## Transmittal

**ATTN:** Greg Scott  
**DATE:** 05/22/12  
**PROJECT:** Munjoy Hill PFD - Monopole  
**PROJECT No:** 2612

Copies	Date	Description
1	05/17/12	Submittal No. 003A - Reinforcing Steel Dwg. No. R01

SHOTCRETE WALL NO. 2

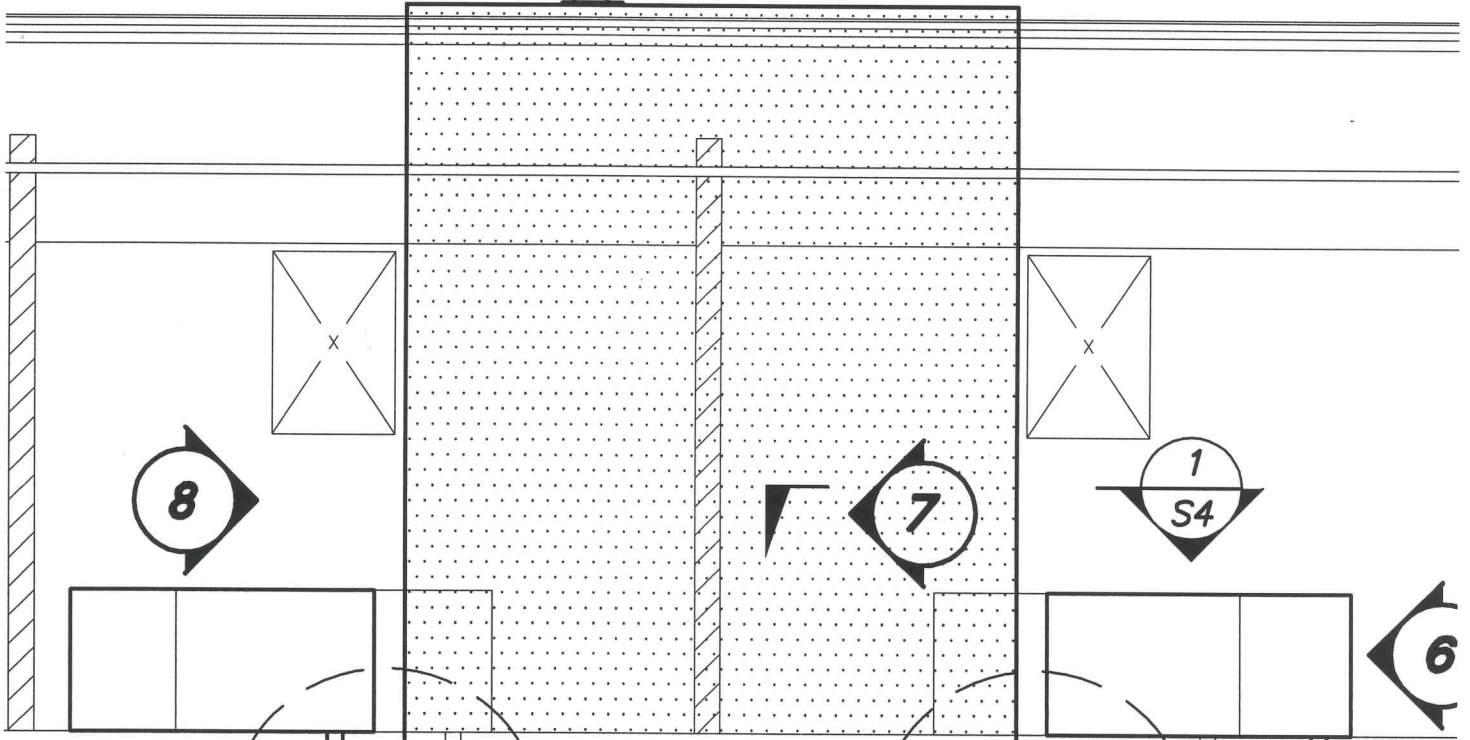
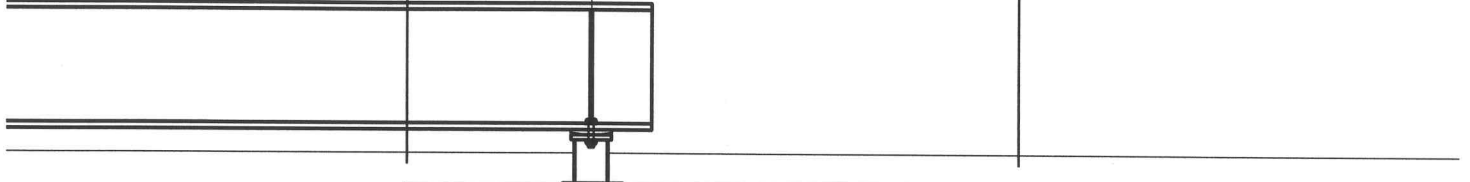
**Comments:**  
 Please coordinate proposed length of shotcrete wall no. 2 with Barker Steel. See attached sketch depicting our understanding of the revised wall length to avoid interference with control joint at shotcrete wall no. 2. If this differs from field measured locations of the control joint please contact us before proceeding with the requested modification. Thanks.
